FORSMAN ENGINEERING

JOB 19026 Sluicer Basin Const - Commencement

SHEET NO. Add 1 OF Add Cycle 2

Restrained Retaining Walls -

SD2

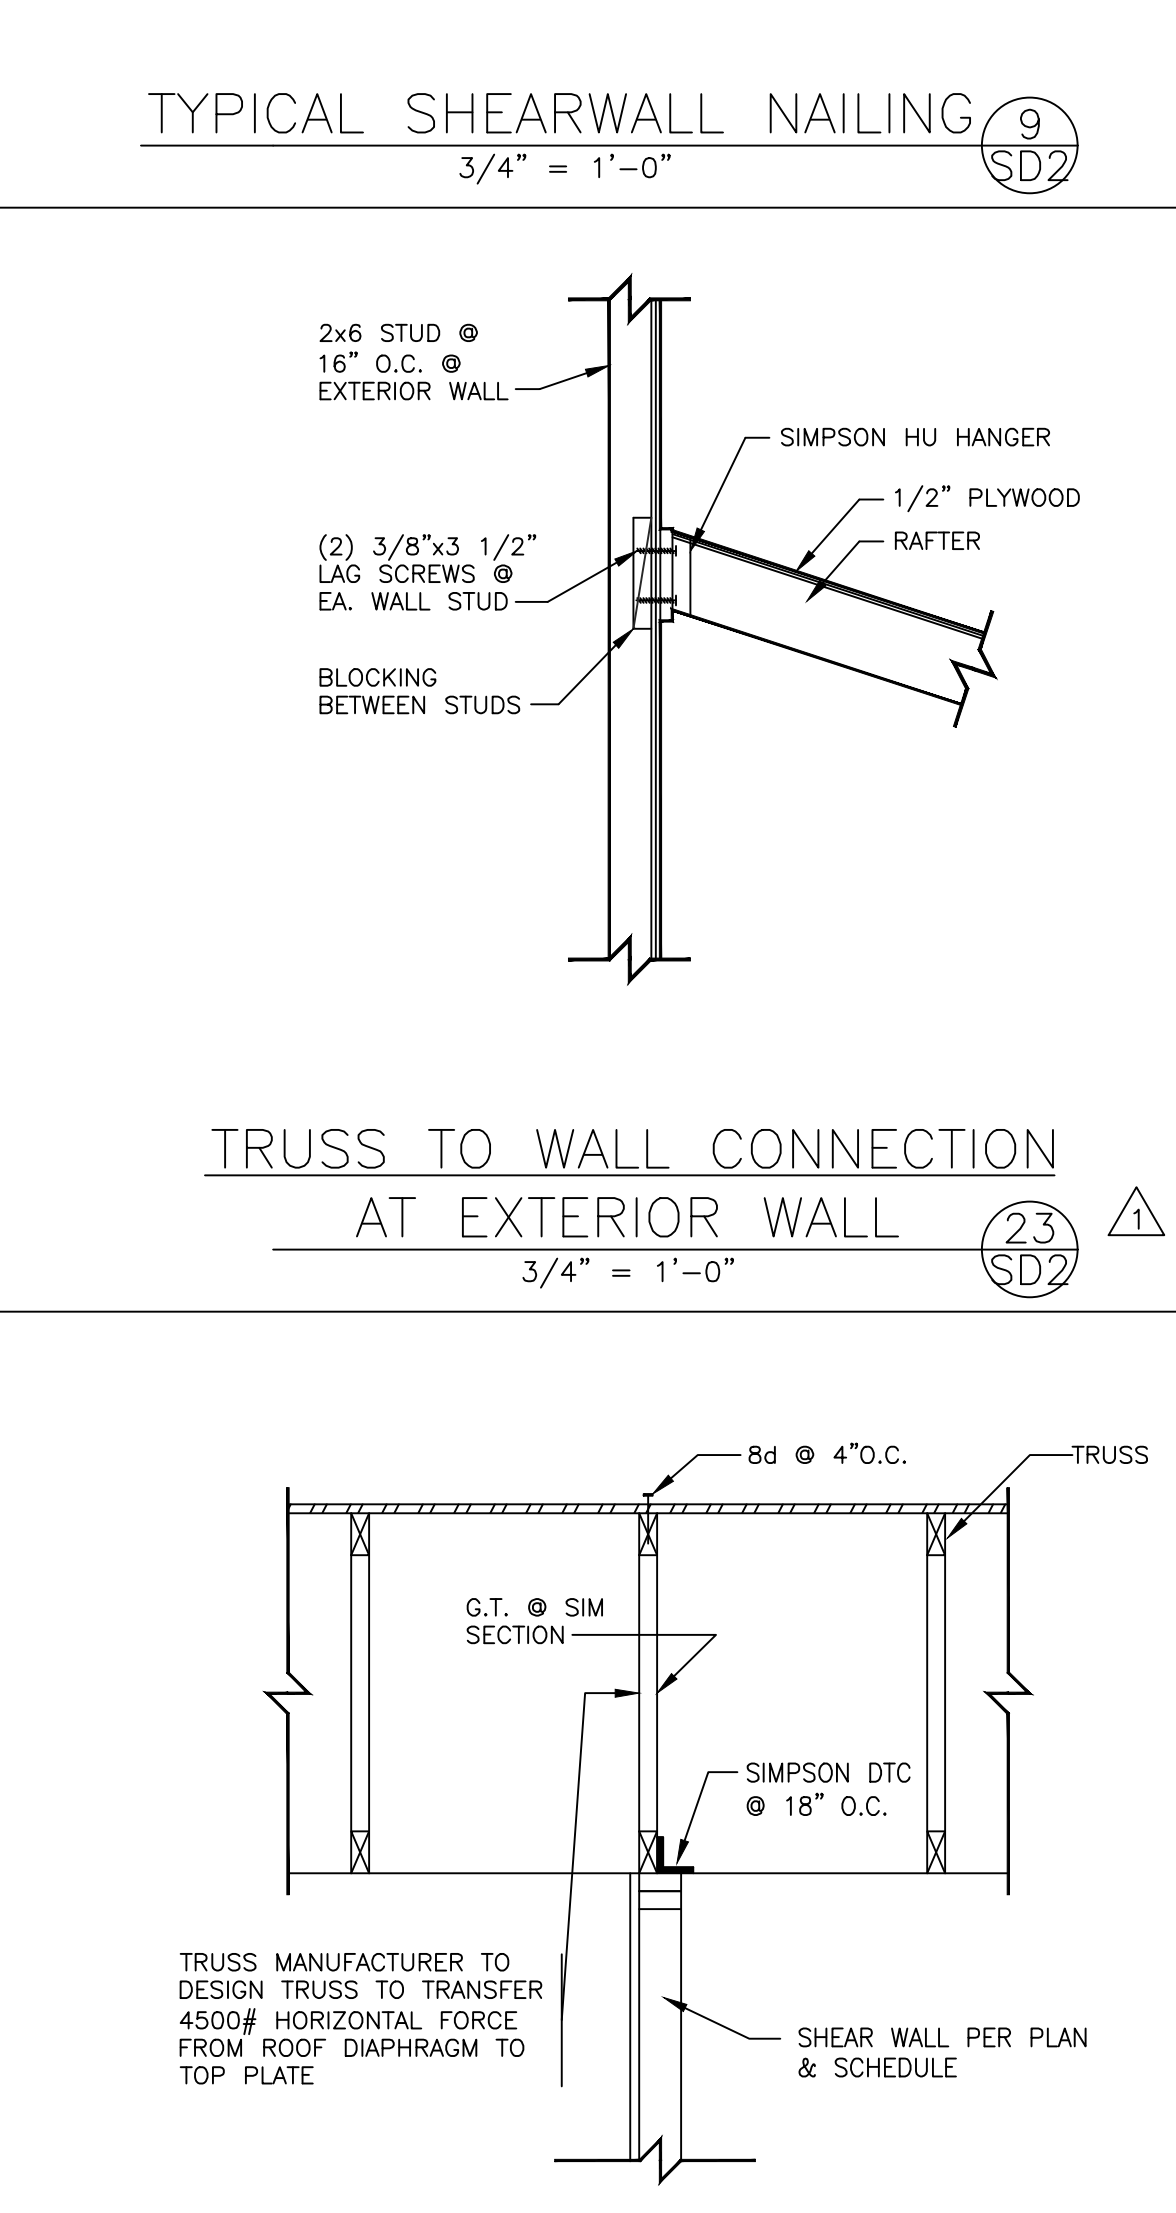
Reference Geotech report JN16448 page 5. As noted in report and confirmed 12-9-20 w/ Rob Ward, the previously un-restrained walls that have been designed w/ 35pcf are fine for stability but when within 1.5h of perpendicular wall additional steel may be required to reduce cracking; therefore, walls have been reviewed below to assure steel will be sufficient for an additional 10pcf x height of wall to the un-restrained active EFP.

Well height	10h	Design Wall height add	Wall design h'
4'	40	40 / 35 = 1.14	5.14
6'	60	60 / 35 = 1.71	7.71
8'	80	80 / 35 = 2.29	10.29
10'	100	100 / 35 = 2.86	12.86

Reinforcing is function of moment, Moment = wh²/6 so only variable h changes; hence, review ratio of

h'/h	Review 1.65 x Mo	Changes
$(5.14)/4^2 = 1.65$	✓	None
$(7.71)/6^2 = 1.65$	✓	None
$(10.29)/8^2 = 1.65$	✓	#5@10
$(12.86)/10^2 = 1.65$	✓	None

Also heel steel moment based on Mw / FS1 as printed, review w/ FS2
